## **Response to Planning application from Hertfordshire County Council (T and CP GDP Order 2015)**

**District ref:** 6/2017/2625/COND

**HCC ref:** WH/285/2017 (Amended)

Submission of details pursuant to conditions: 5 (details of new roads, accesses, cycleways and footpaths), 6 (Surface water drainage scheme), 7 (site investigation), 9 (Reptile Survey), 12 (details of floor lighting and external lighting) and 13 (details of open storage) on planning permission 6/2015/2043/OUTLINE dated 05/07/16

Drawing title	Status, Drawing number & revision	Amendments
Proposed Site Plan	3280/ 130 5	Site Entrance re-worked
Drawn by	Checked by	A1 Scale
EM	MR	1 : 500
		A3 Scale
		Date
		15/12/2017
		14:41:00
		Status
		TENDER

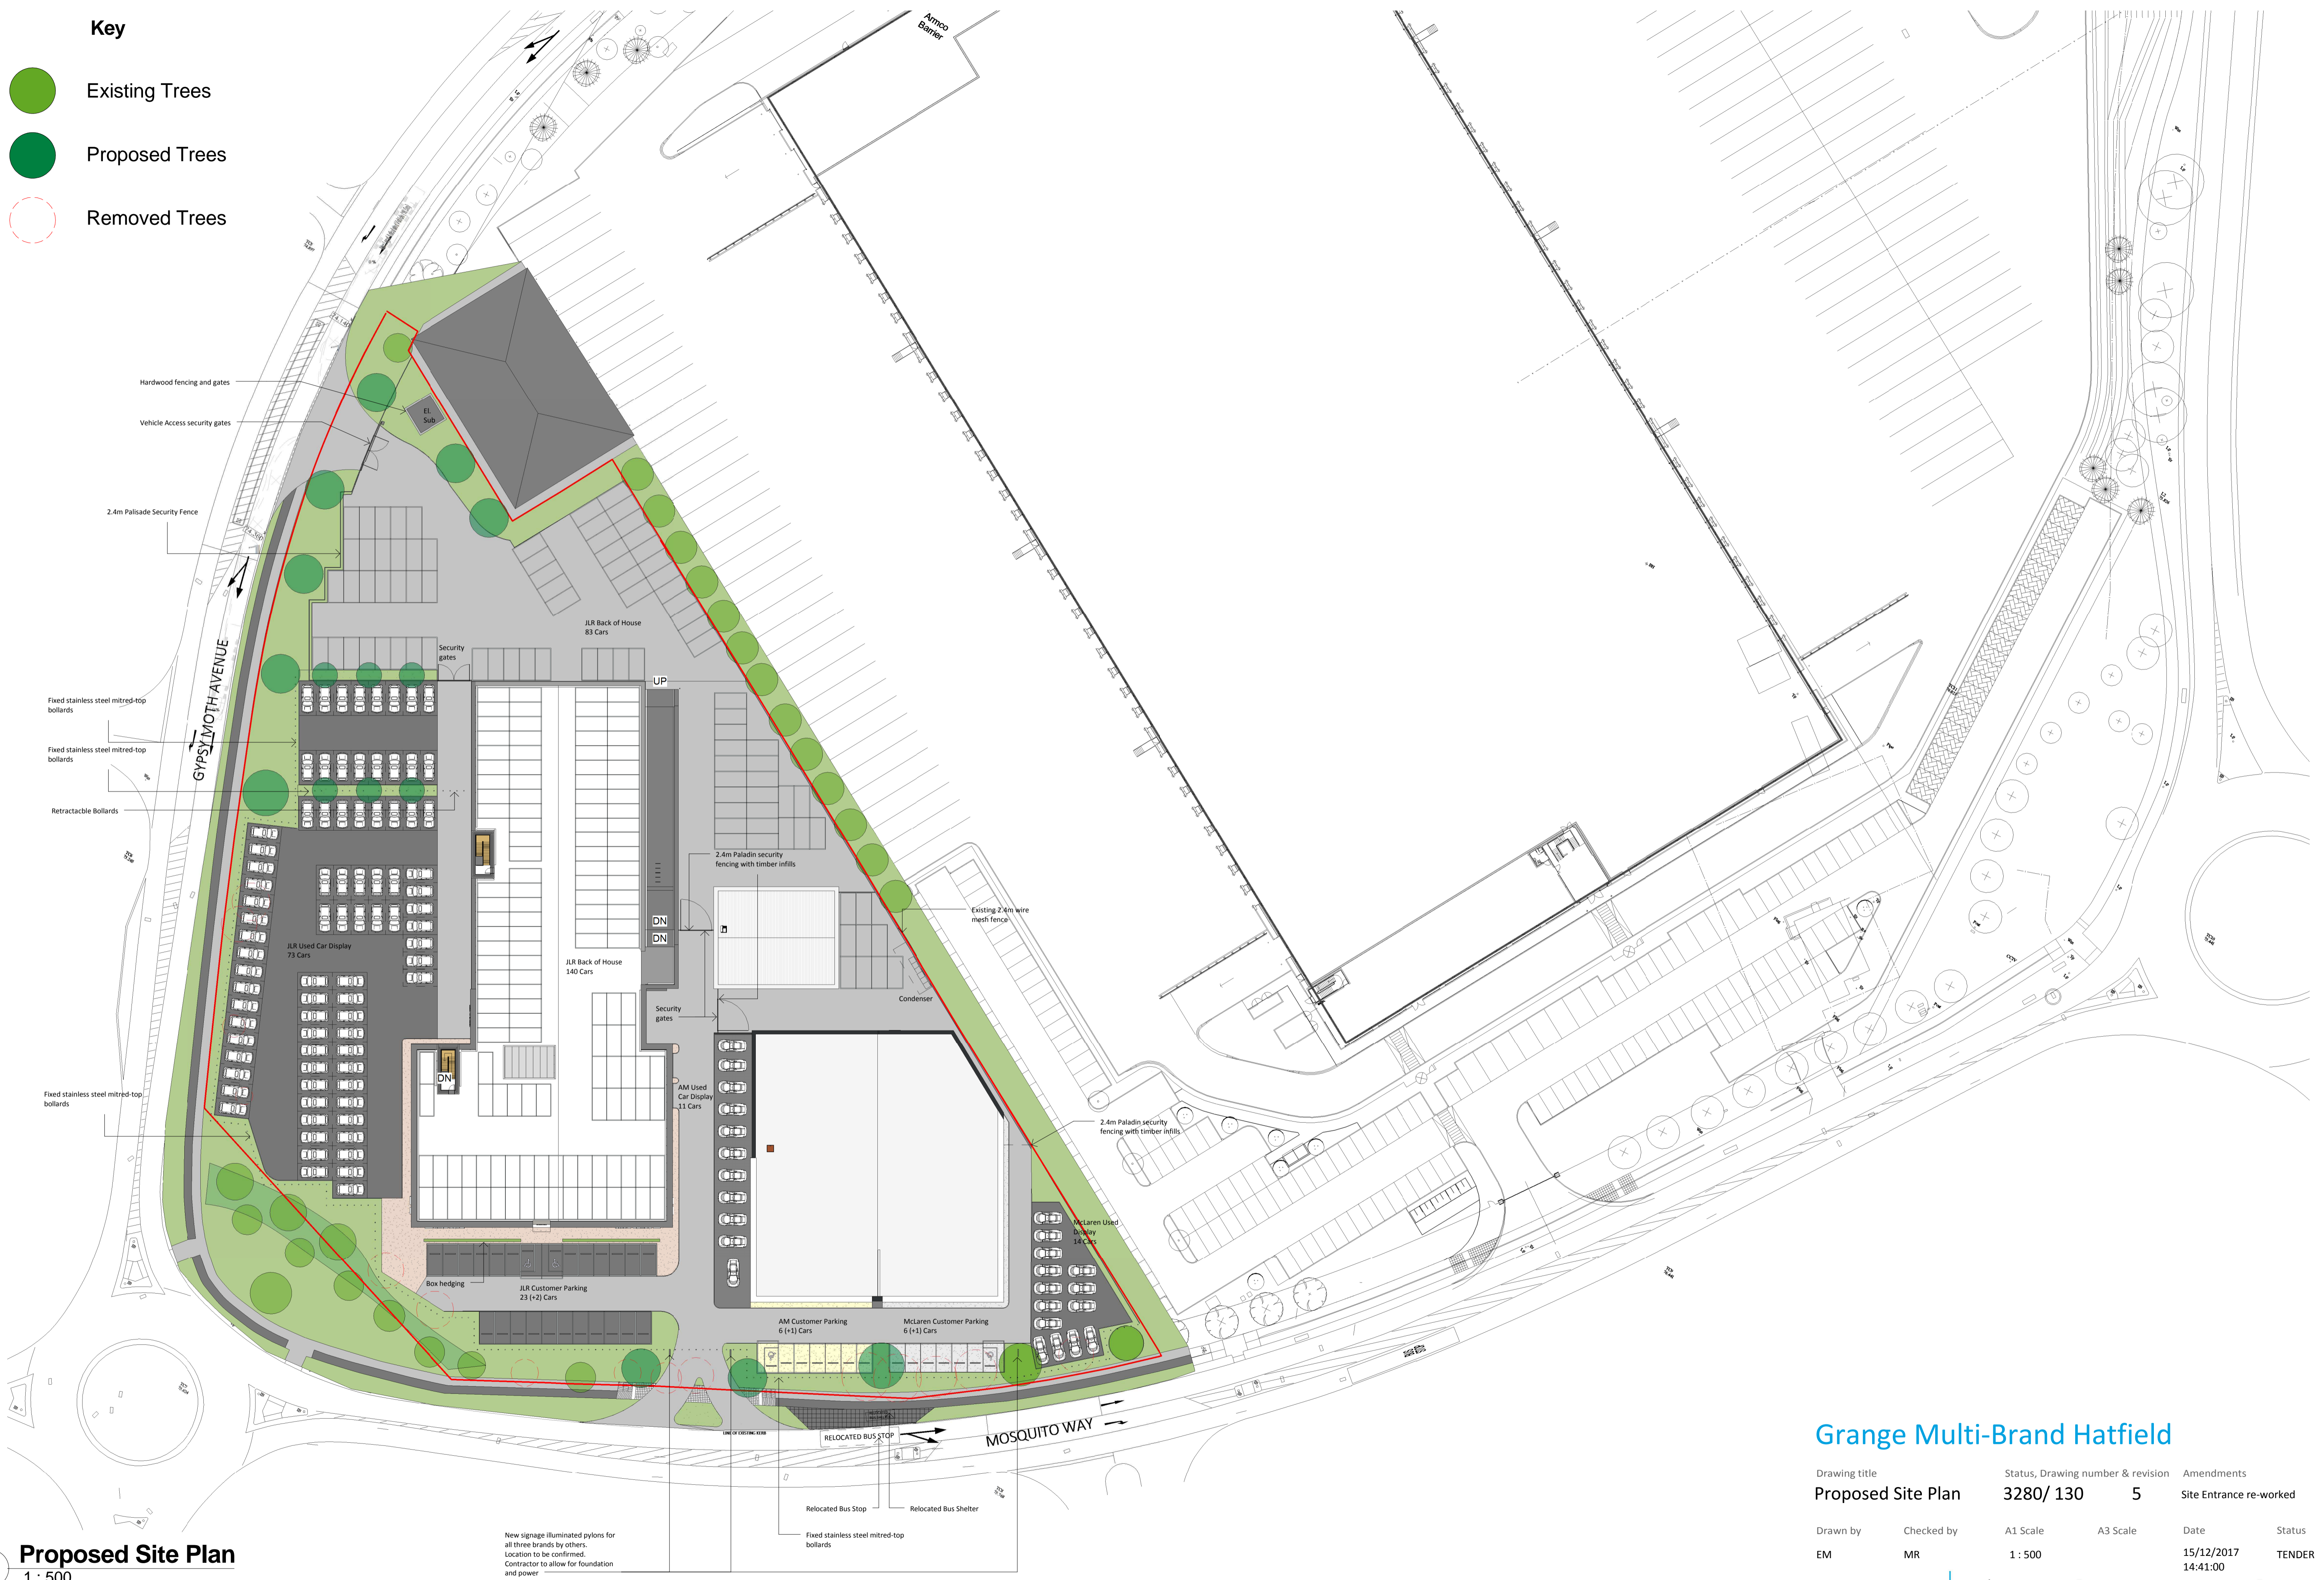
Details shown on drawing 3280/130 relocate the bus shelter to a point closer to the new access. The justification for this is unclear. There are no highway benefits to its' relocation and concern is voiced that it is too close to the proposed new access. There have been no discussions with the Highway Authority in regard to proposals to relocate the bus shelter. The distance moved is insufficient for it to have any benefit to accessibility to stops (walk time). The relocated position provides no benefit to vehicles on Mosquito Way if a bus is in position at the stop, still providing no opportunity for safe overtaking. No evidence is available that alternative locations for the bus stop (east of junction of Trident Place / Mosquito Way) have been considered. Concern is voiced over downstream congestion impacting on the adjacent roundabout junction which would not be an issue if the stop was located further to the east.

The Highway Authority consider that it is reasonable that the bus stop / shelter is proposed as relocated in order to maximise the visibility to passers by to vehicles on display (SE corner of plot 4100) with the new bus shelter location obscuring what appears visitor parking. Given the above concerns, the Highway Authority are not satisfied that the suggested bus stop location is appropriate.

The provision of Kassel kerbing for the shelter, and the requirement to provide dropped tactile kerbing to serve the pedestrian crossing (refuge) on Mosquito Way in advance of right hand turn lane, presents concerns over the gradient of transition between these opposing levels in such close proximity to each other.

The developer has taken on board earlier expressed concerns of the Highway Authority that the central refuge provided to the new access / egress onto Mosquito Way failed to provide for the segregated cycleway / footway. The central refuge has been extended and now ensures that the refuge aligns with the entire width of the cycleway / footway.

The Highway Authority remain concerned that the refuge is insufficient in width (at back edge) to accommodate cyclists safely. TA91/05 (DMRB) Provision for Non-Motorised Users Summary directs “6.19 ...The preferred crossing width for cyclist refuge islands is 3.0m to 4.0m (2.5m at constrained locations).”

Drawing 3280/130 Rev 5 features inconsistencies – whilst described as 1:500 at A1 – the scale bar does not conform to this. Introducing concerns for scaling.

Whilst corduroy tactile is provided at both ends of the segregated cycleway either side of the new access, and therefore the crossing is unsegregated shared space, this shall introduce a departure from the desire line and introduce greater risk of conflict between pedestrians and cyclists by encouraging them both to gravitate towards the wider area provided in the refuge. In the absence of a Stage 1 RSA demonstrating that the use of the refuge island for all road users the Highway Authority remain concerned with the proposals.

Reference to vehicle tracking, drawing ITB13336-GA-007 demonstrates that opportunities exist to increase the size of the refuge without affecting the general location of the access / egress.
